Application No: BR/263/20/HH
Site Address: 44 Corbishley Road Bognor Regis PO21 9HS
Description of works: Detached single storey outbuilding

Thank you for your internet representation made on 8th December 2020 which has been recorded as an objection with the comments as follows:

PROPOSED DETACHED OUTBUILDING AT 44, CORBISHLEY ROAD, BOGNOR REGIS
FOR MR. A. PAULVR,

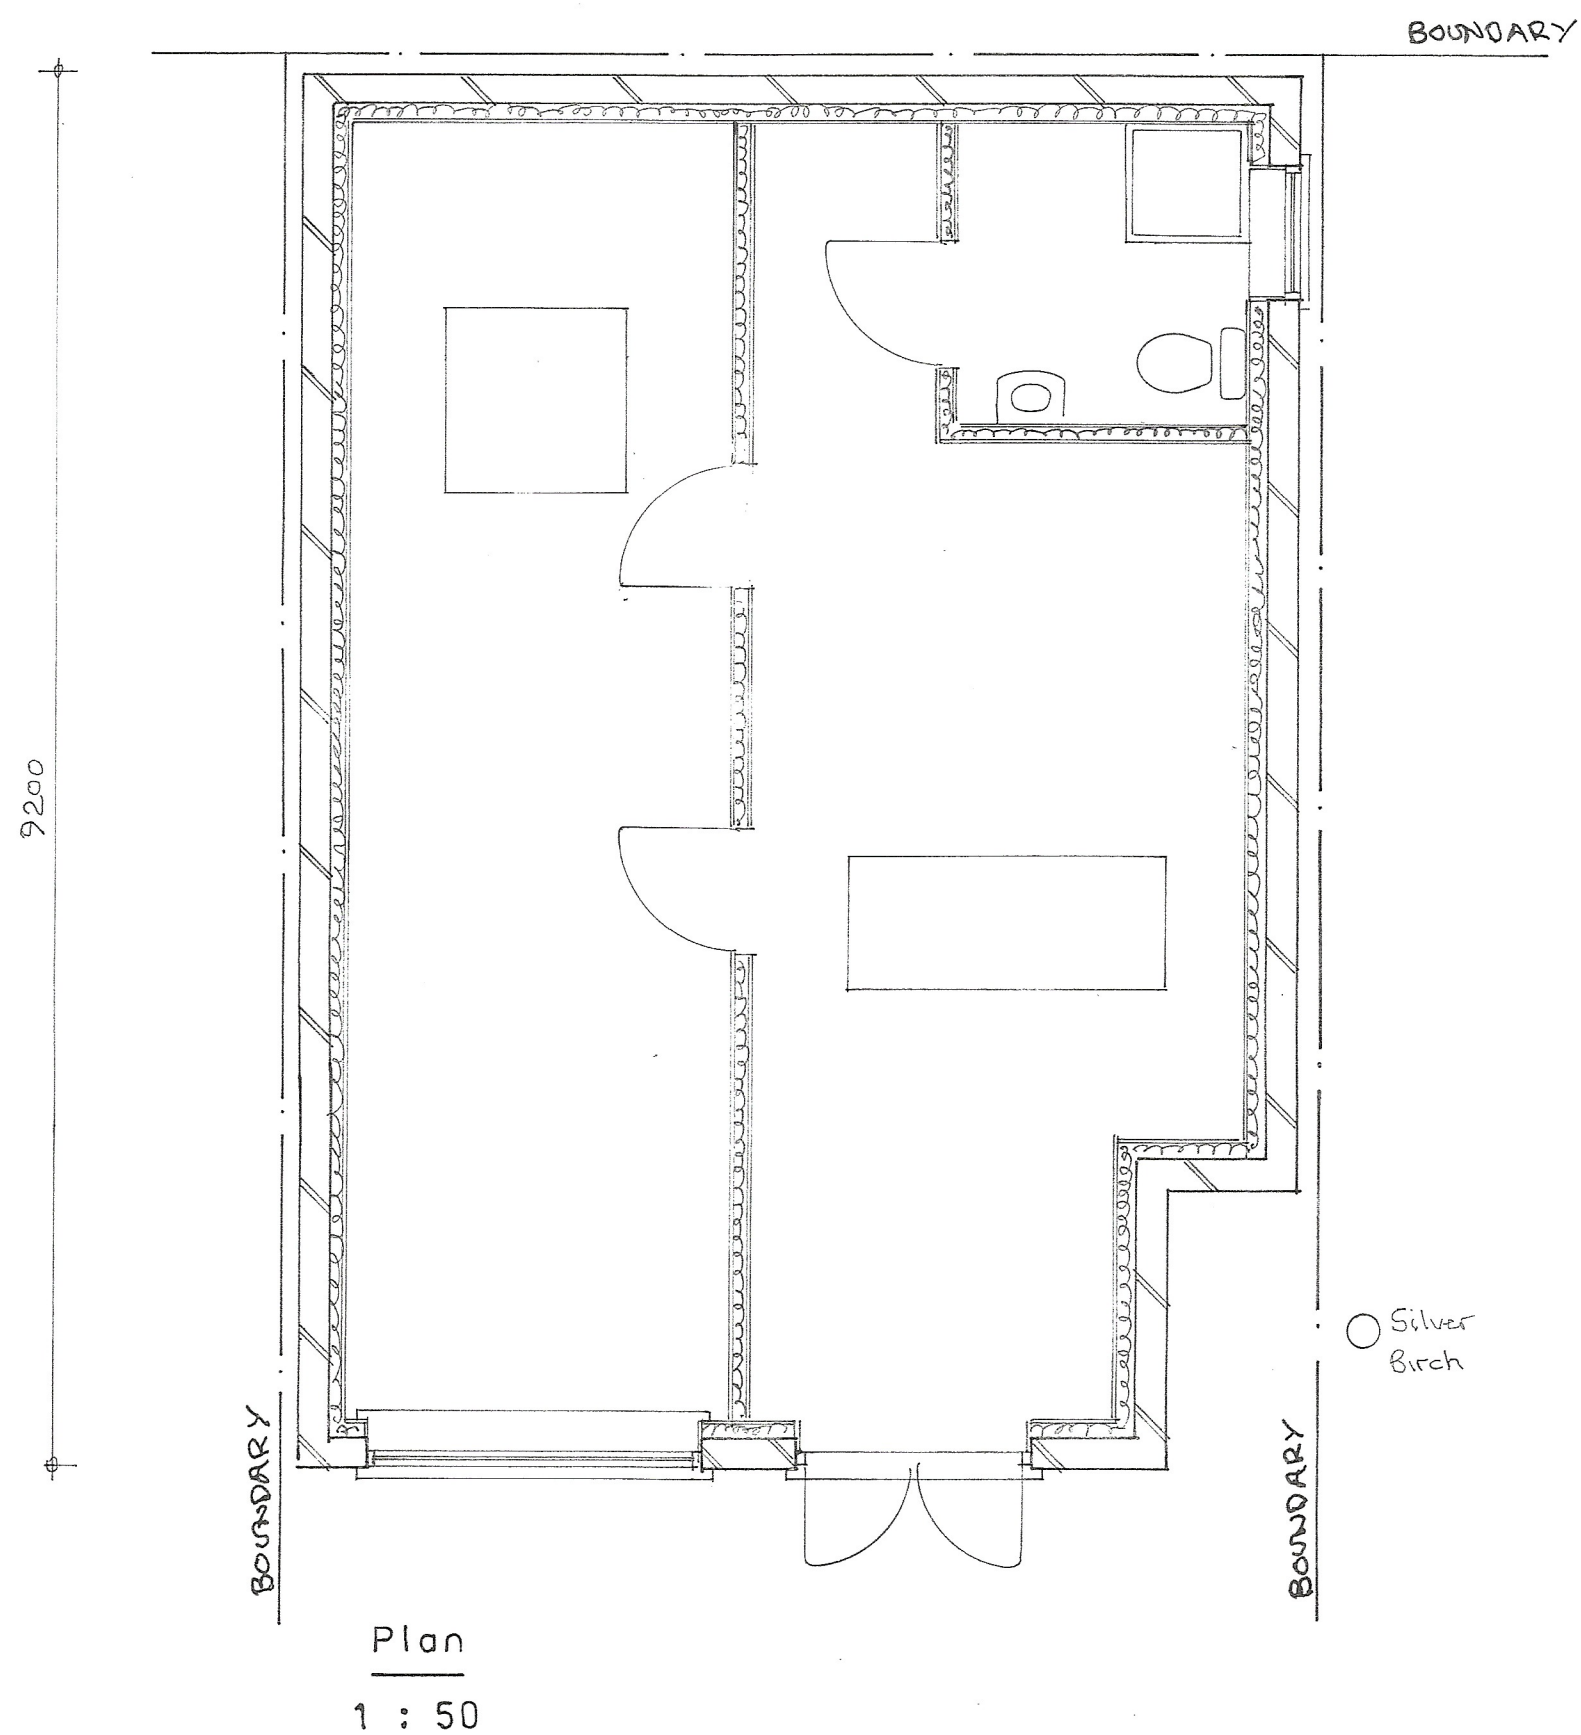
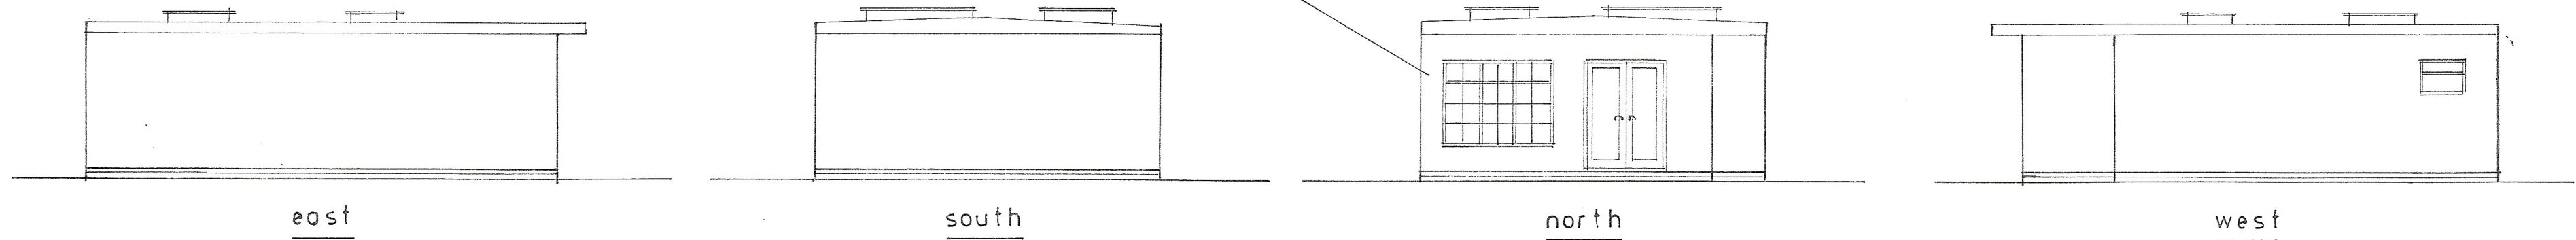
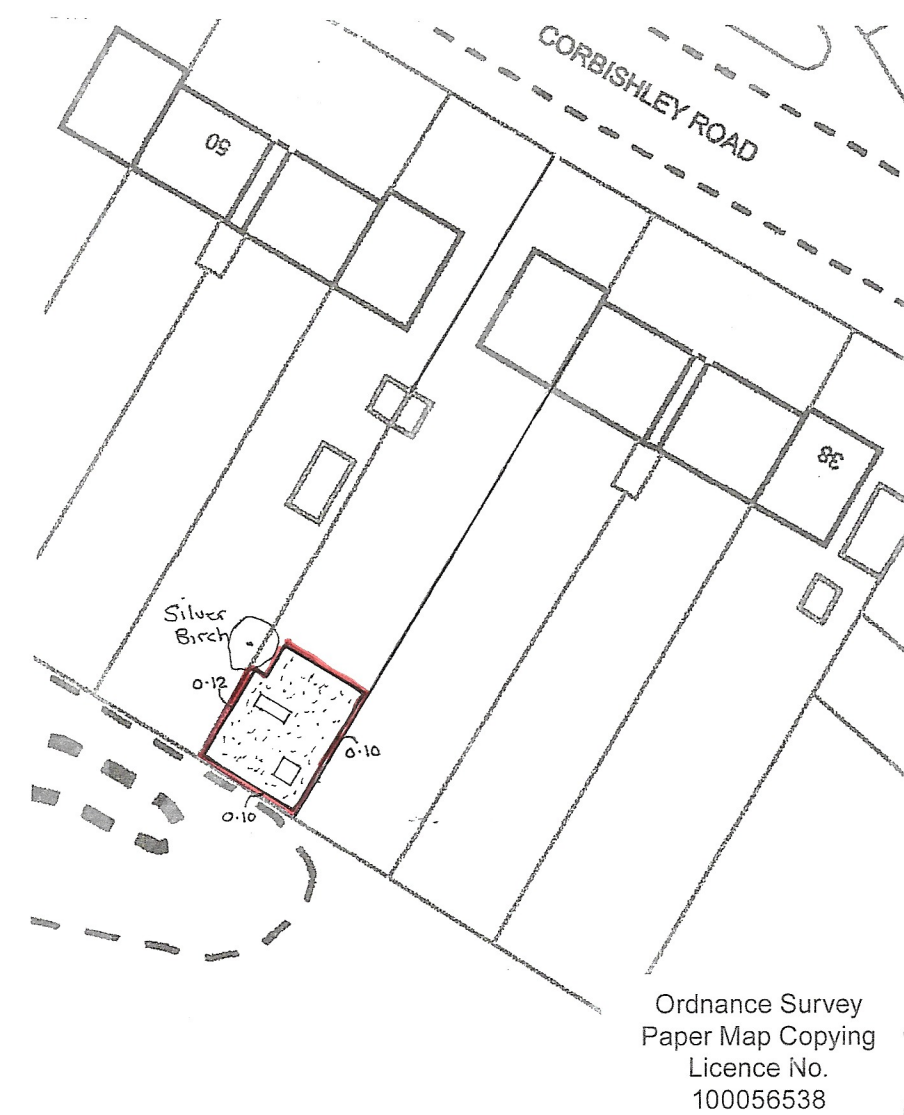
there is also a window on east elevation not shown on plans.

its a very large imposing building looking back at all the houses in the row, taking away all privacy
